Summary of Natural England's Written Representations advice in respect of A46 Coventry Junctions (Walsgrave)

HE604820-OIL-EBD-00-DR-LB-30063

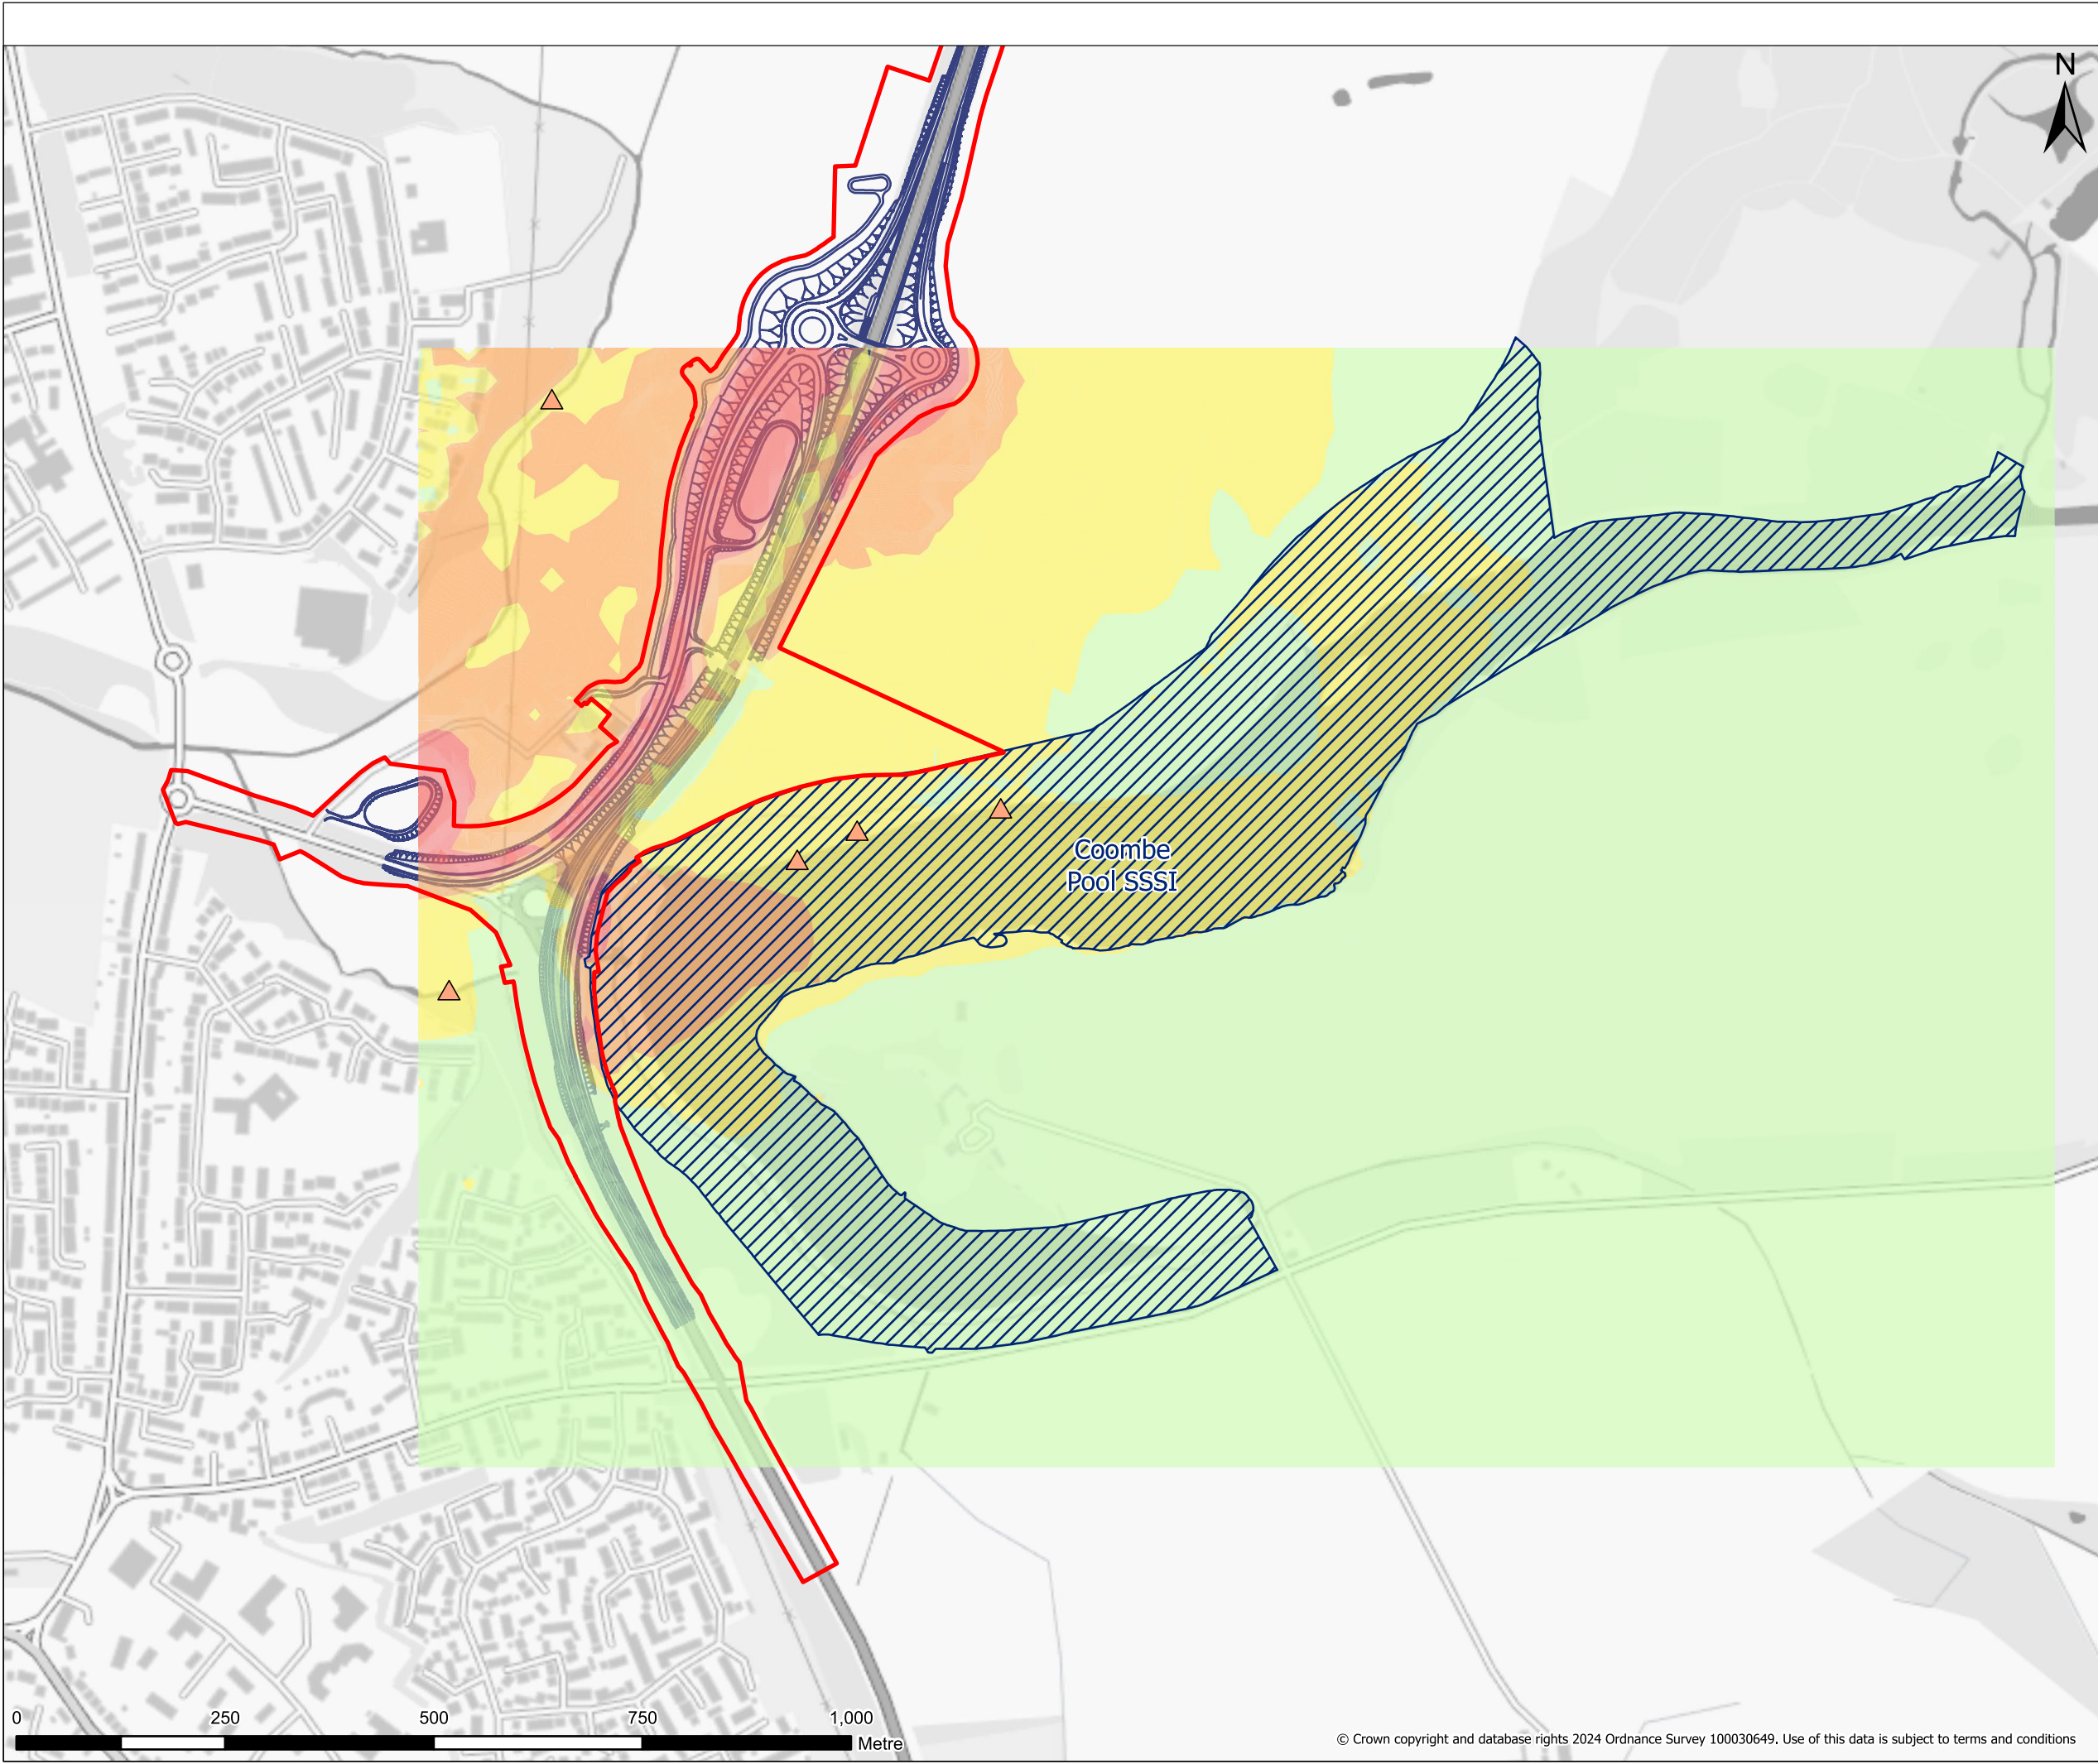
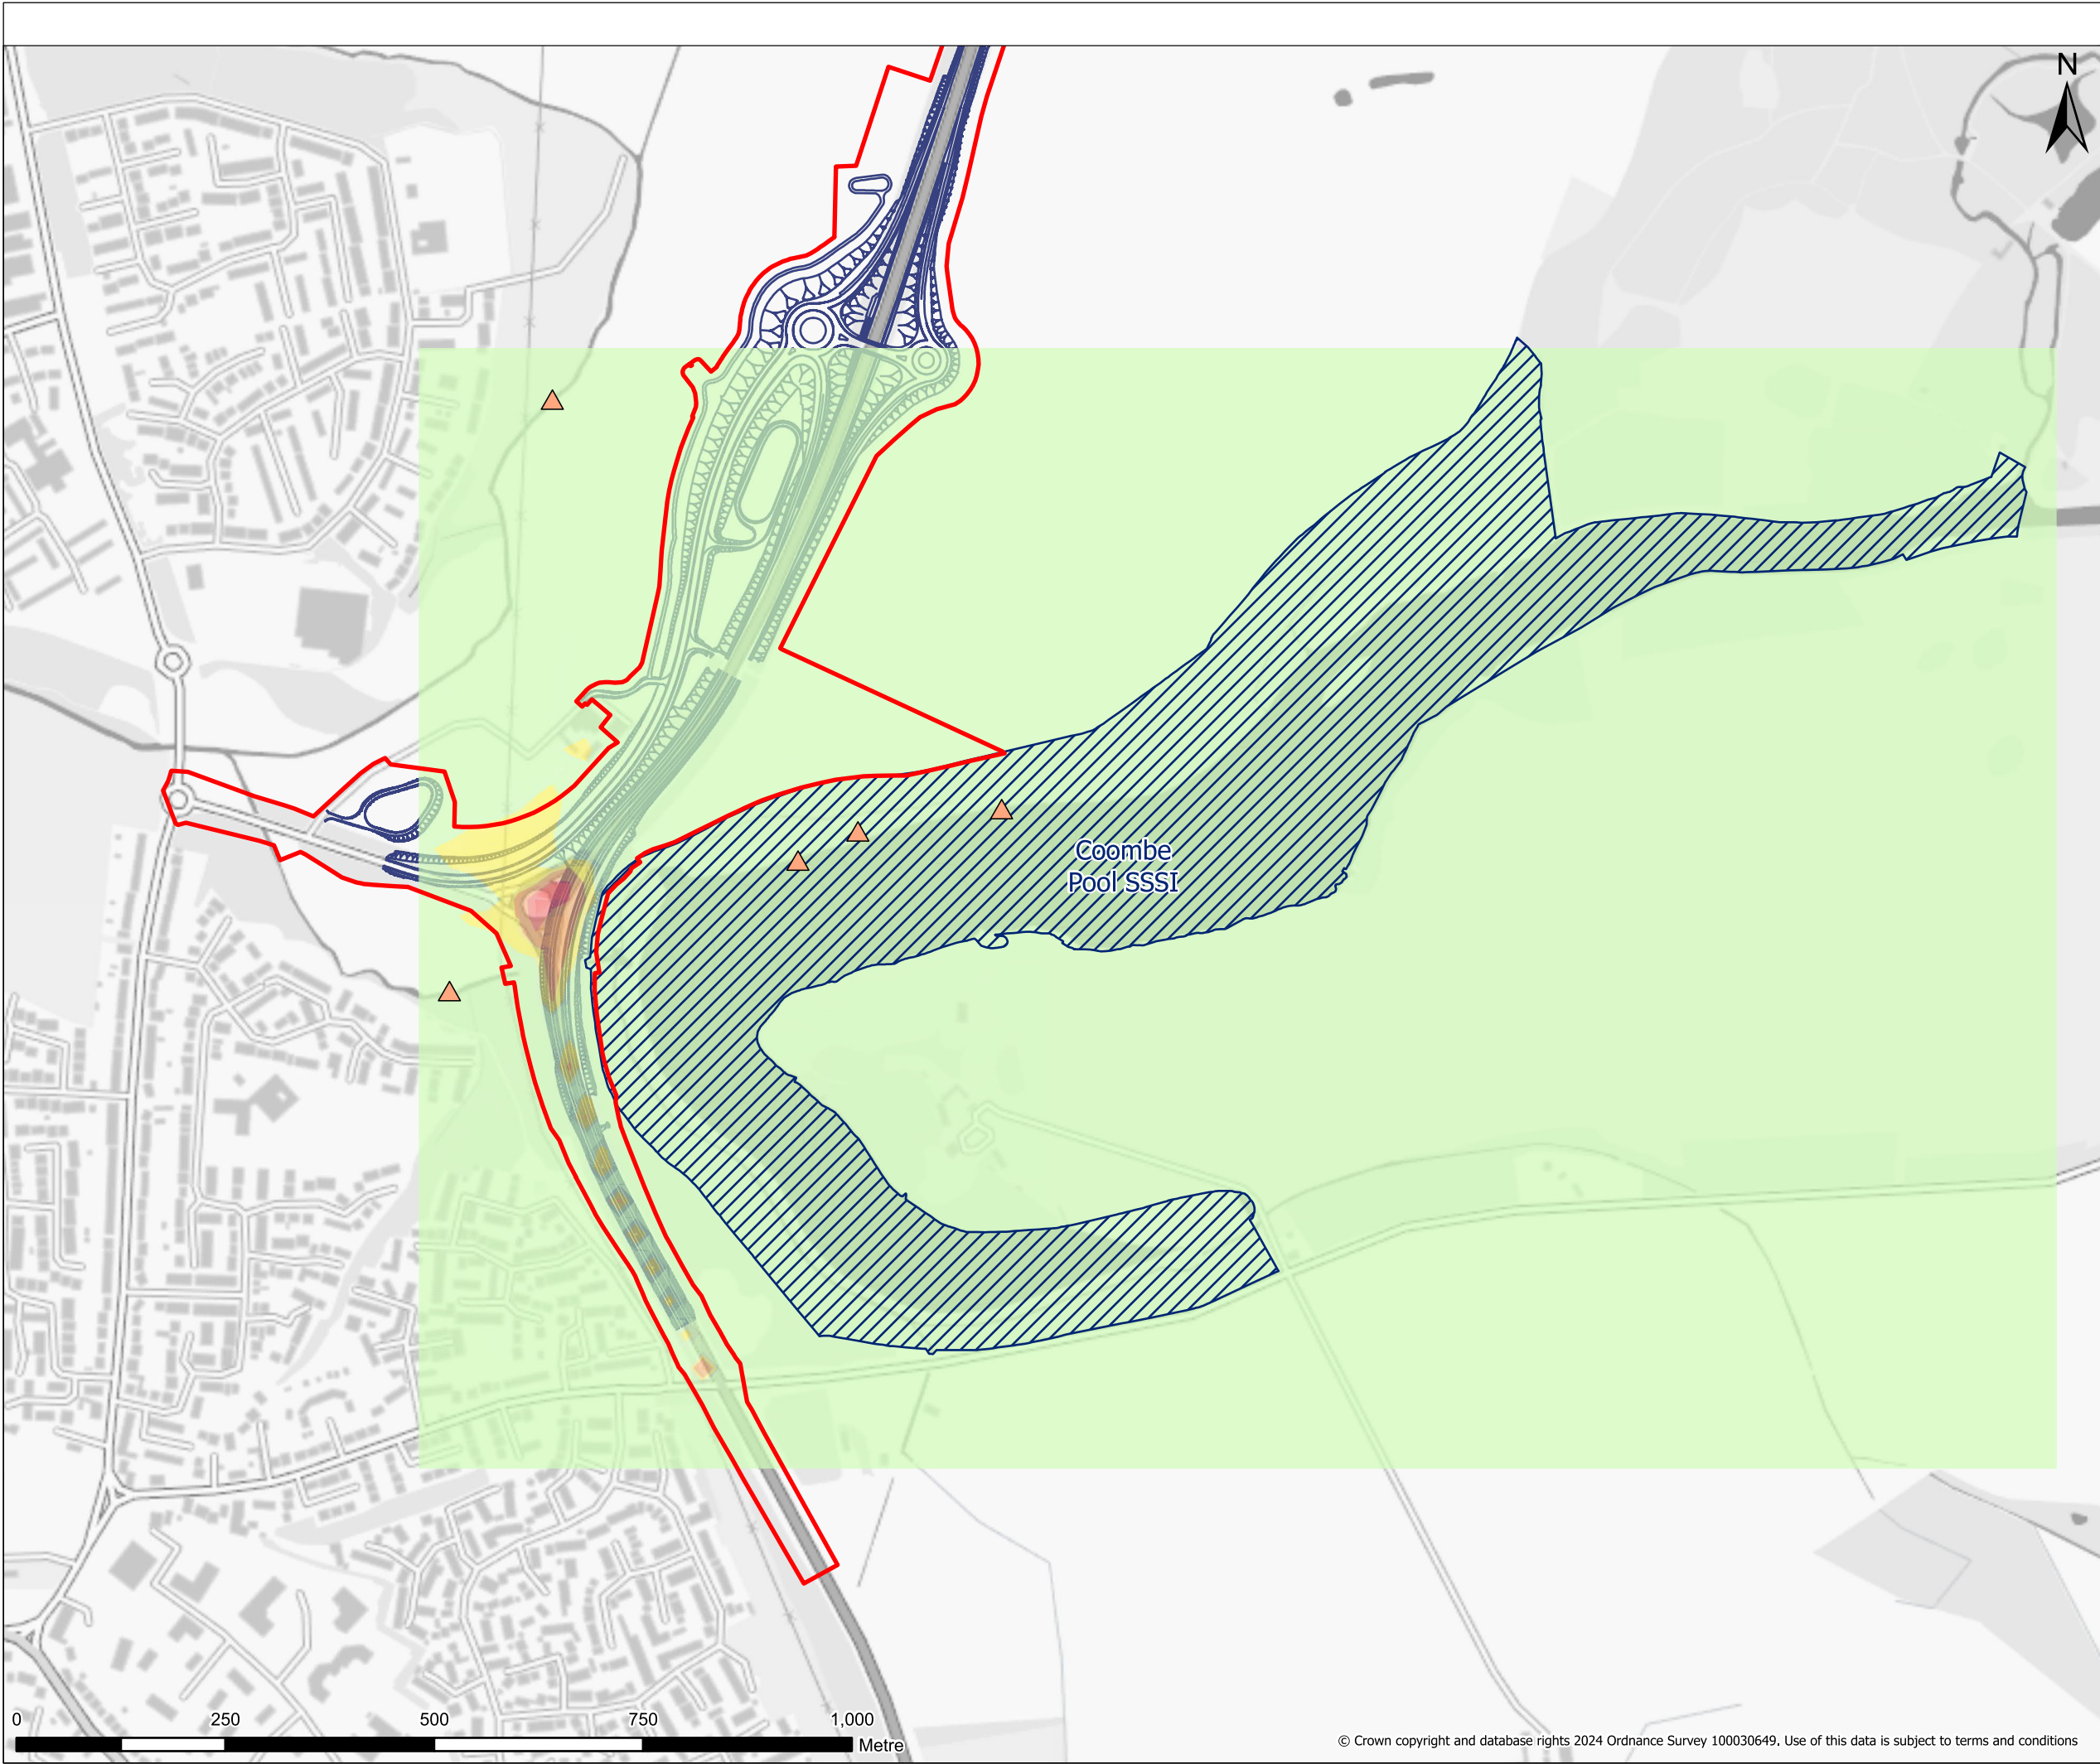
- Impacts of noise and lighting on Combe Pool SSSI and mitigation to prevent impacts (NE4).
- Impacts from air quality (NOx, NH3, N dep) on Combe Pool SSSI and Herald Way Marsh SSSI (NE6).
- Impacts on water quality and water quantity on Combe Pool SSSI and Herald Way Marsh SSSI (NE7).
